From: Clerk Yapton Parish Council [REDACTED]
Sent: 17 May 2014 11:17
To: Planning.Responses
Subject: RE: Planning Consultation on: Y/32/14/L

APPLICATION **Y/32/14/L**
NO:

Site Address: Hobbs Court Bilsham Road Yapton BN18 0JY

Description of Application Listed Building Consent for proposed conversion of

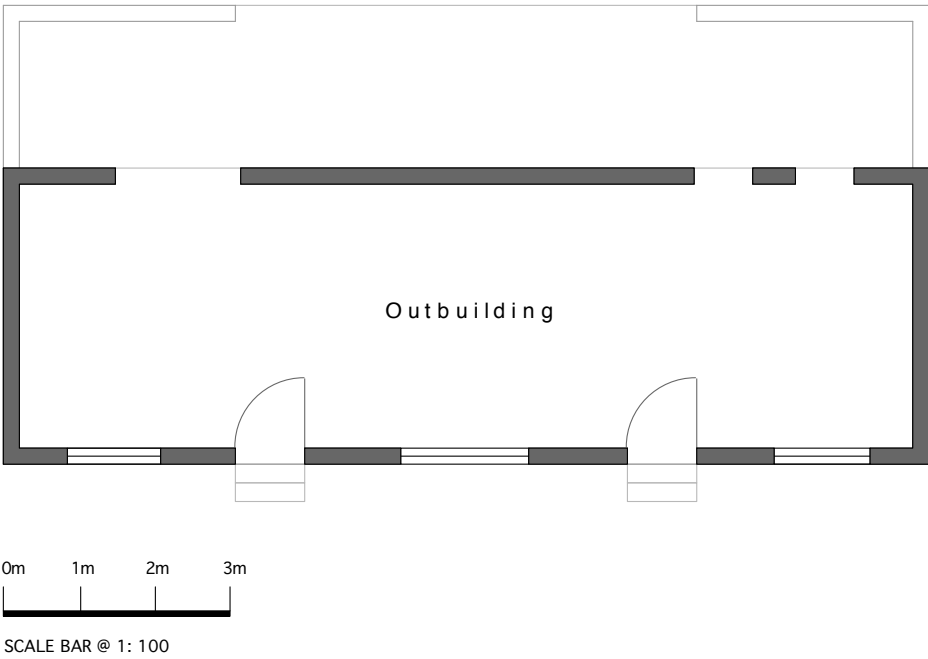
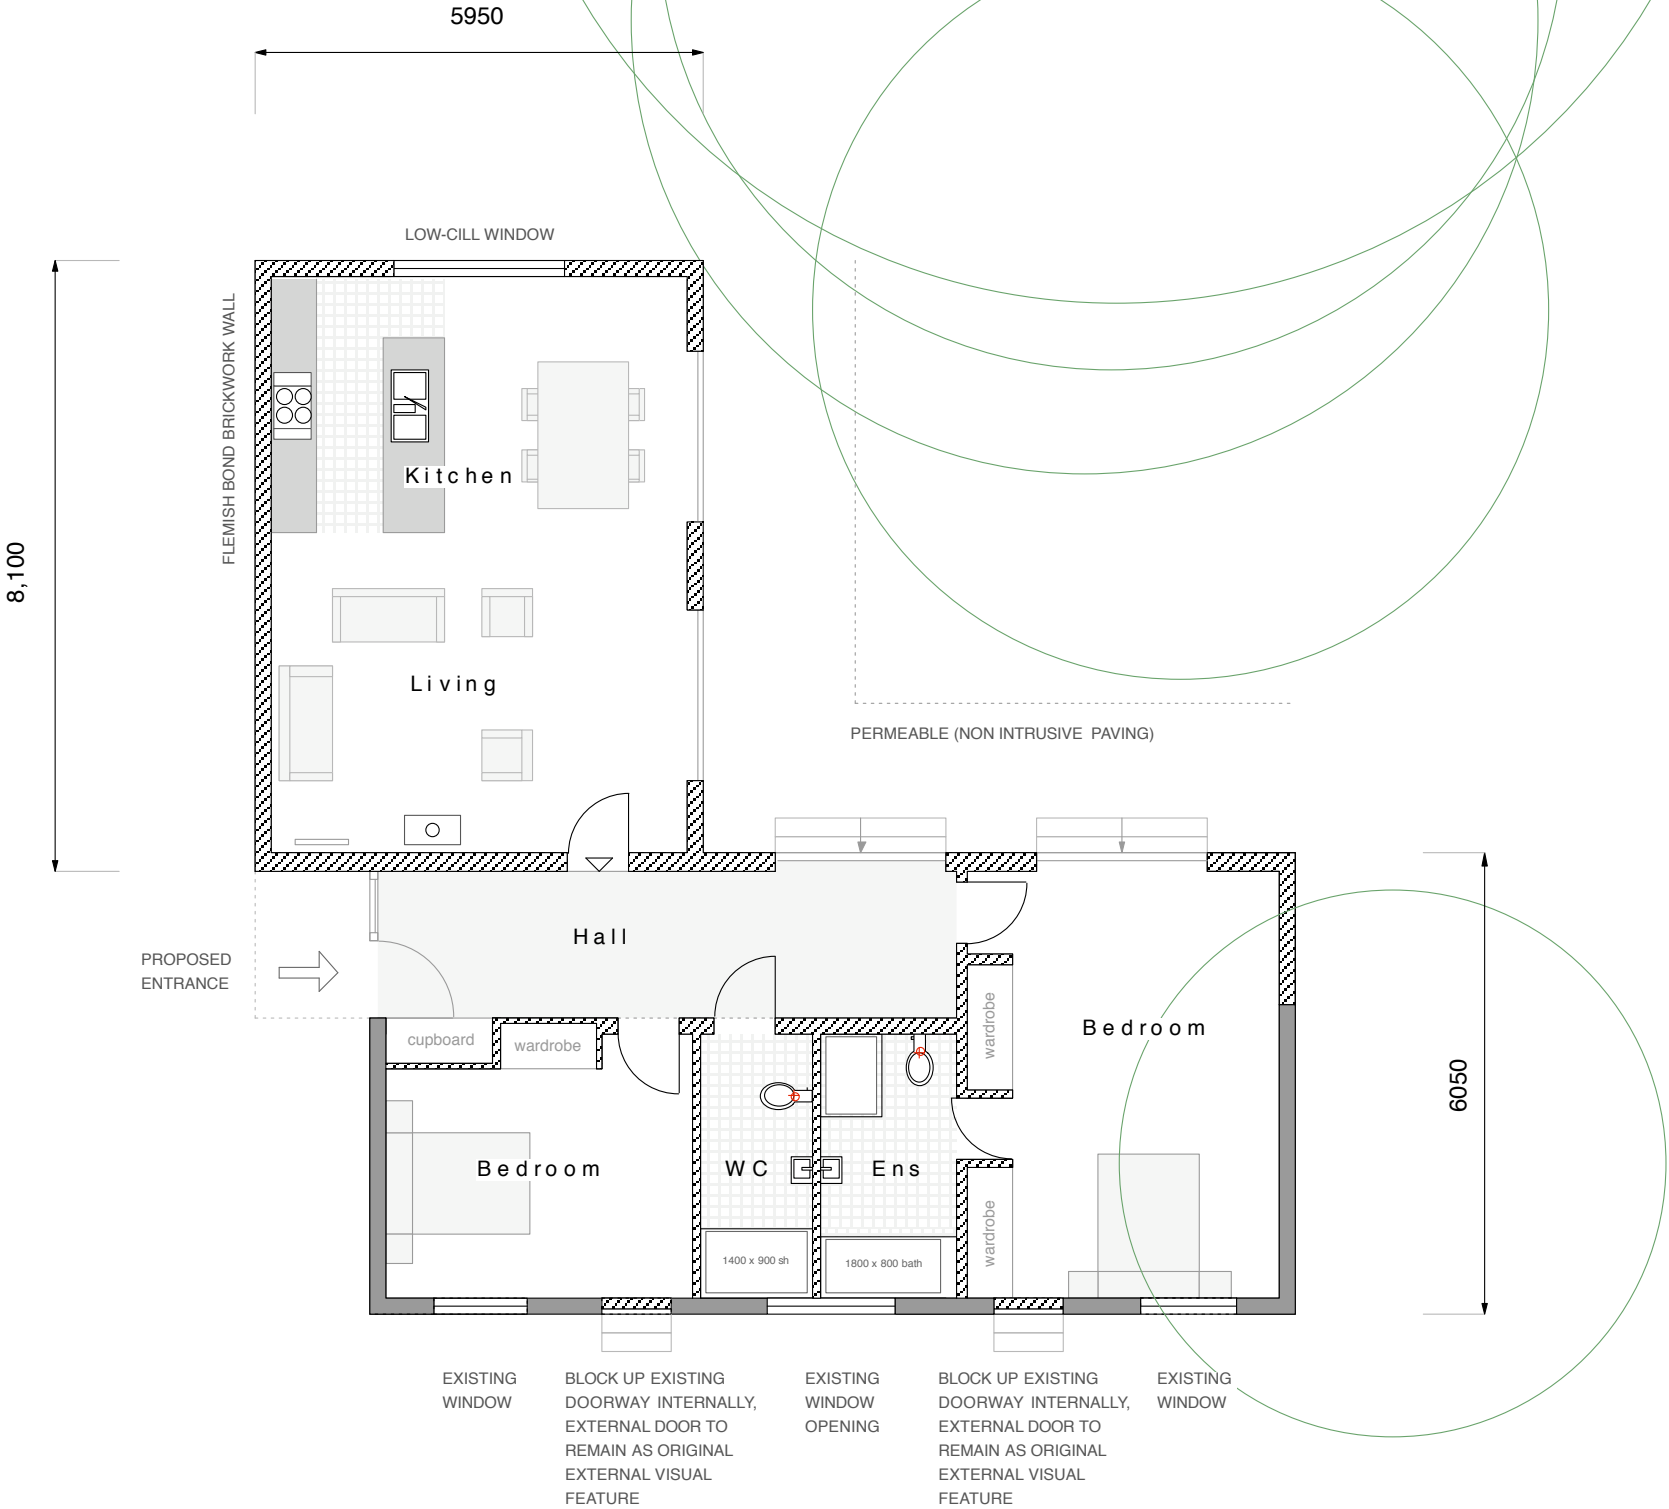
- i) the footprint of the existing building will be increased by in excess of 100 per cent;*
- ii) the character and appearance of the existing buildings will be dramatically altered;*
- iii) the building is listed or within the curtilage of a grade 2 listed building;*
- iv) unable to find any proof in the documentation that the existing building has been used for domestic residential use.*
